CITY OF ALBUQUERQUE

February 19, 2021

**RE: Palomas Peak Phase 2
Grading and Drainage Plan
Engineer's Stamp Date: 02/09/21
Hydrology File: D19D031**

CITY PROJECT No. **D-19-Z** ZONE MAP No. **1** SHEET **1** OF **2**

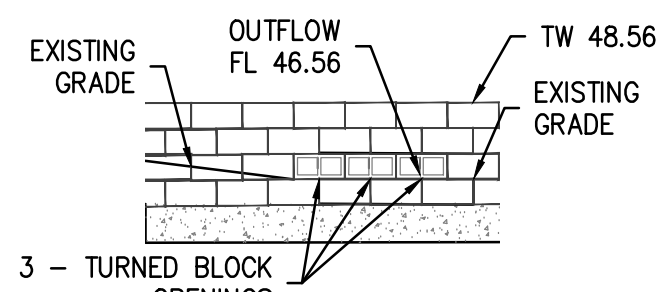
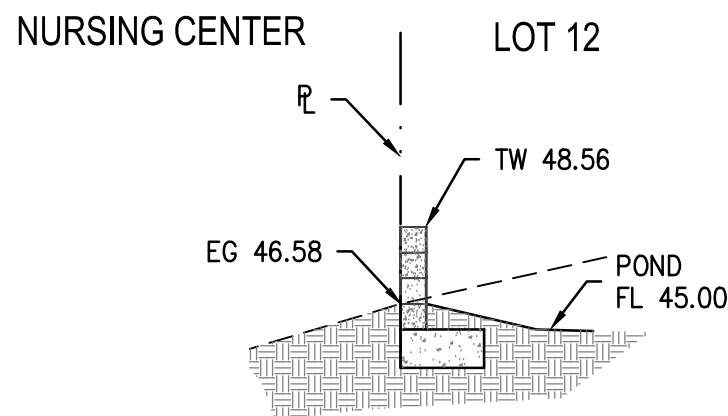
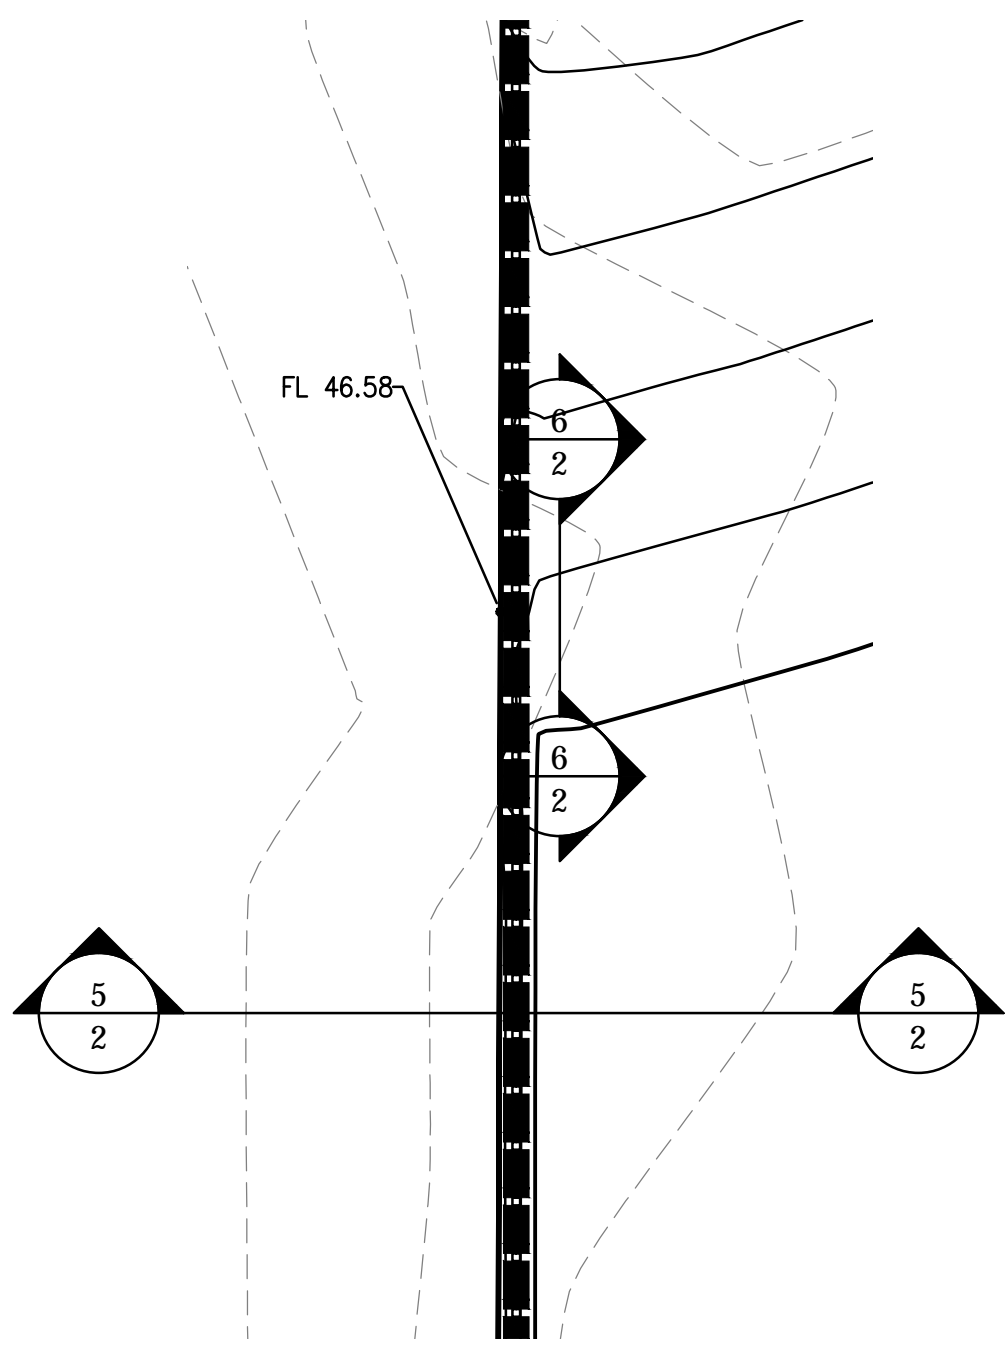
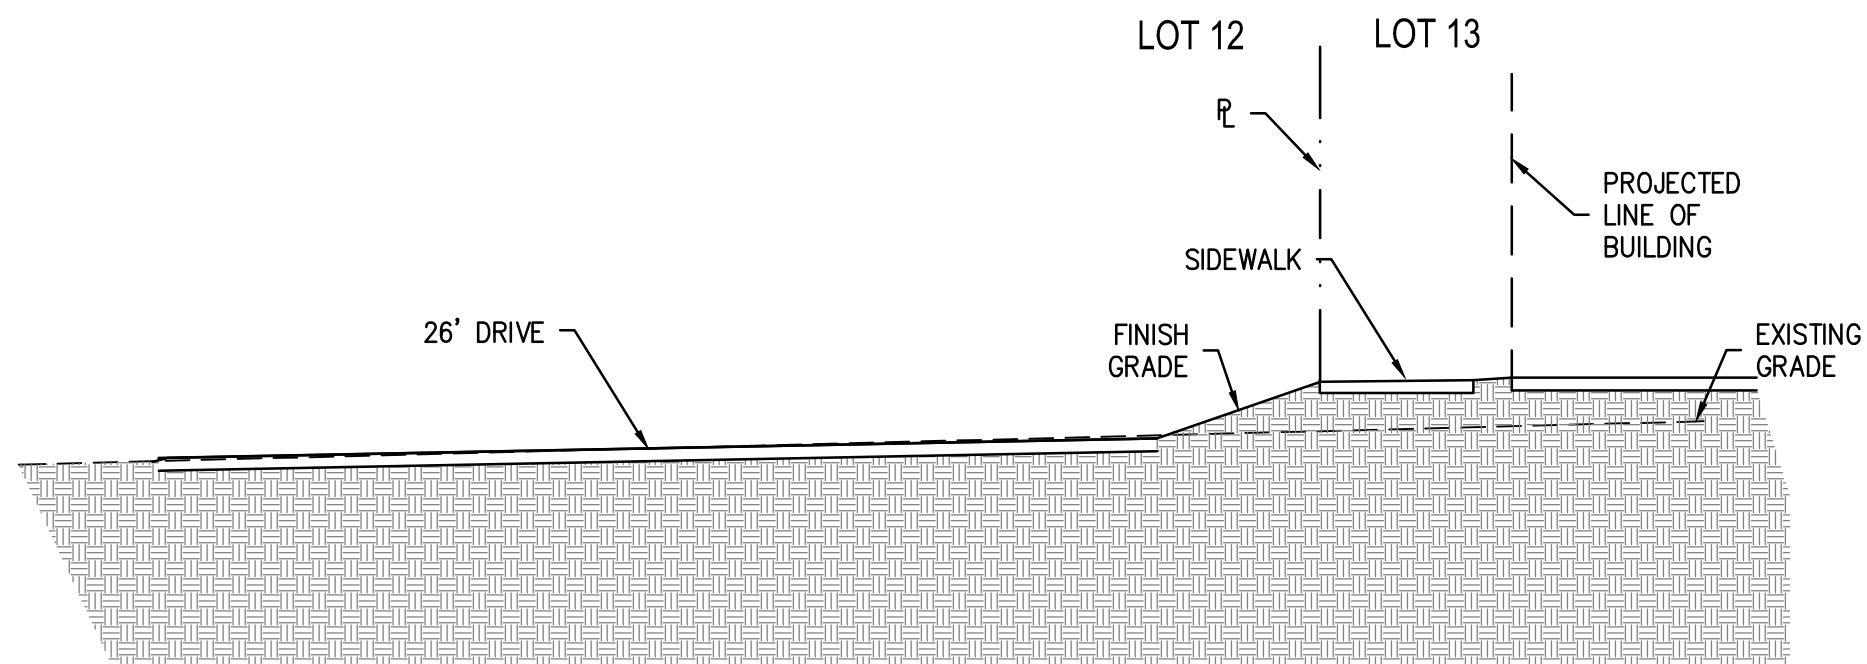
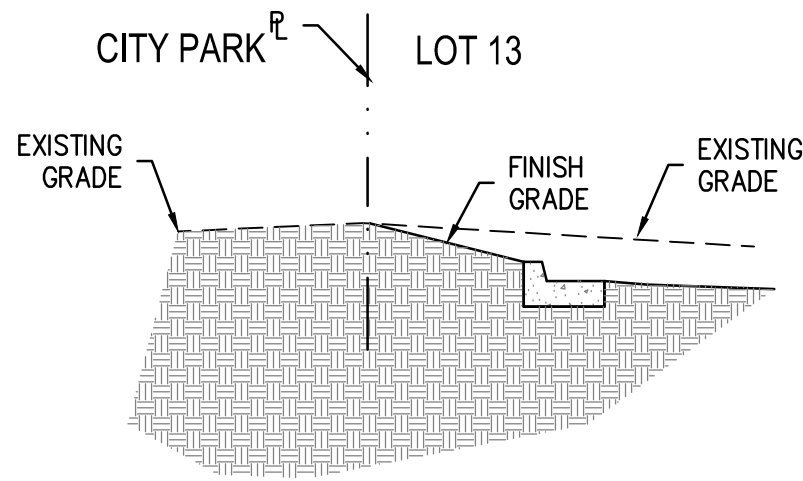
1. Sheet 1. Please label all the adjacent lots and the project lot. The lot to the east is missed labeled.
2. Sheet 1. I am not following what the two inlets with the 36-in storm pipe is doing. It is not connected to the detention pond. Please elaborate what this is doing and how it is connecting to the detention pond.

3. Sheet 1. Again, I am not following what the 42-in storm pipe is doing. Please elaborate the function of this pipe since it appears that there is nothing connected to it.

4. Sheet 1. Please take off the word "Temporary" for the detention pond. This can be reshaped during the Phase 2 design, but a detention pond will still be needed after the Phase 2 design.

5. Sheet 1. The label for the pond view on Sheet 2 is not the correct drafting standard. What you have shown is a section label. Please correct. Typically, this is just done by a note.

6. Sheet 1. Please label the existing retaining wall built in Phase 1 with the existing top of wall. Then ass the top of the new wall course that you are extending upward. Also I need you to label where the new retaining wall is starting with the top of the wall elevations all around the wall.

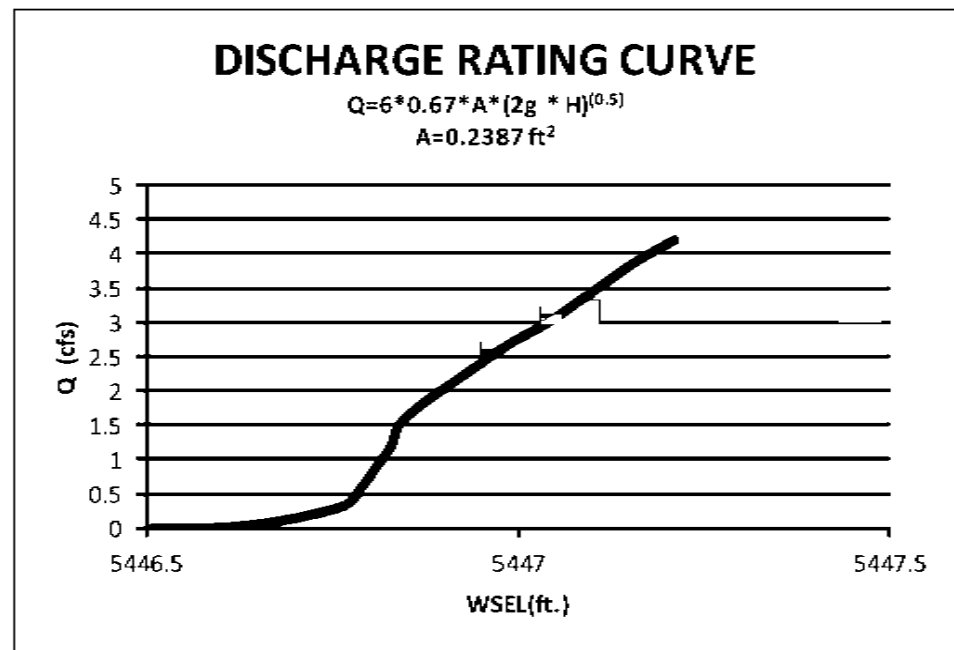
7. Sheet 2. Section 1. This section seems to be incomplete. It really seems irrelevant as shown. Please fix or delete.
8. Sheet 2. Pond Detail 4. Please flip the section arrow for Section 6, since it should be facing the retaining wall.

9. Sheet 2. Section 5. This section is incorrect. The section needs to not only show the existing retaining wall built in Phase 1, but the extension of that wall here in Phase 2, the bottom of the detention pond, the proposed retaining wall (Section 7), and the 100 year – 24 hr water surface elevation. Along with some horizontal dimensions.

10. Sheet 2. Section 6. Please show the existing section of retaining wall that was built with Phase 1 and a new built portion since you are extending the wall up.

11. Sheet 2. Section 7. Please correct the section label. Also, please show the 36-in storm sewer in the sections since it appears to be installed right up against the retaining wall.

12. Sheet 2. Section 7. Please correct the section label.
13. Sheet 2. Please add a detail showing how the two inlets with the 36-in storm pipe system is connecting to the detention pond.
